COUNTY COUNCIL'S RESPONSE TO CONSULTATION ON THE FOLLOWING DEVELOPMENT PROPOSAL

Application No: 21/00500/OUT

Proposal: Erection of up to 43 new homes, access from Station Road and associated works including attenuation pond

Location: Land North of Railway House Station Road Hook Norton

Drawing Title **Indicative Surface Water Drainage Arrangements**

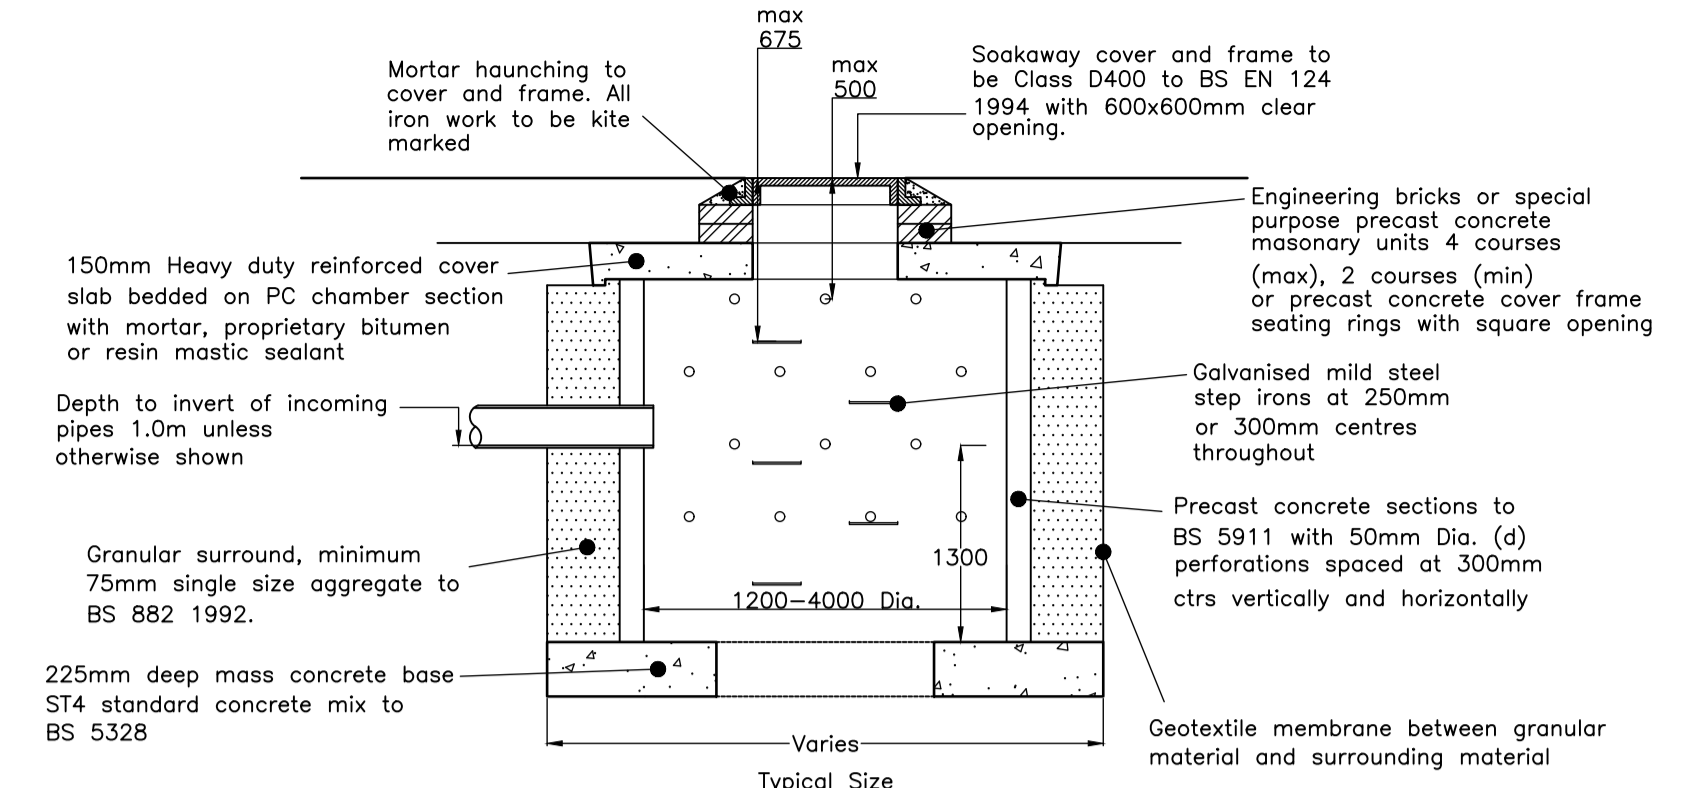
There are discrepancies between the report and the calculations provided. This needs to be clarified;

- Rate used in Microdrainage 3.23×10^{-5} m/s, but rate stated on investigation report and FRA is 3.31×10^{-5} m/s

Infiltration trial locations stated in the plan do not correlate with the drainage layout. The trial locations must be where infiltration has been proposed.

As there are numerous infiltration locations proposed, several tests are needed in order to conclude with a conservative rate.

There is no mention of soft standing and hard standing areas in the report. A total of 0.062ha is used in the microdrainage calculations, this needs to be clarified.

Maintenance plan and exceedance plan are not submitted.
